Harnett County Government Complex
307 W. Cornelius Harnett Boulevard
Lillington, NC 27546

March 23, 2017

Re: Status of Improvement Permit Applications # 17-5-40905

# Harnett County Department of Public Health Site Sketch

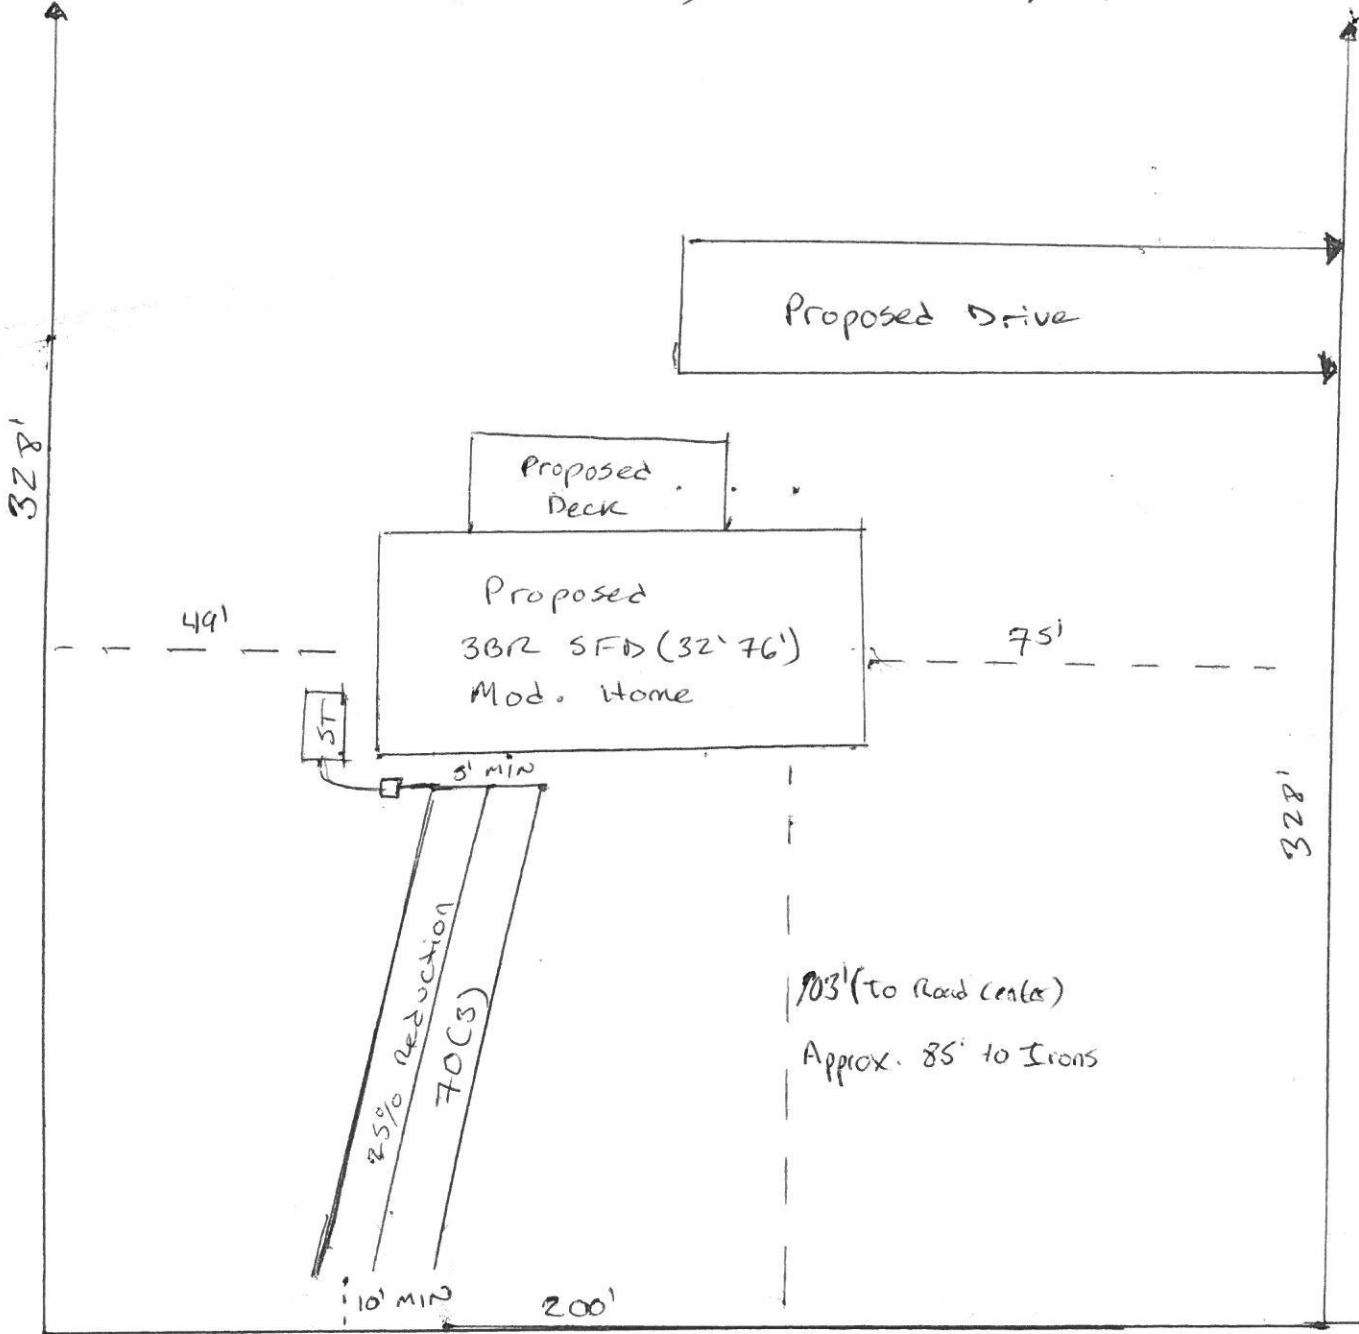
- 1. Use pink flags to mark property lines and irons that are set by surveyor need to be visible *(\$25.00 fee incurred)*
- 2. Use orange flags to mark house corners *(\$25.00 fee incurred)*
- 3. Directions not clear to property *(\$25.00 fee incurred)*
- 4. Property needs only brush or vegetation removed
- 5. Driveway not shown on site plan
- 6. Backhoe pits required
- 7. Other – Not all property irons were displayed please locate and flag. Show proposed driveway on your site plan. Revise and resubmit as a revision to Central Permitting.**
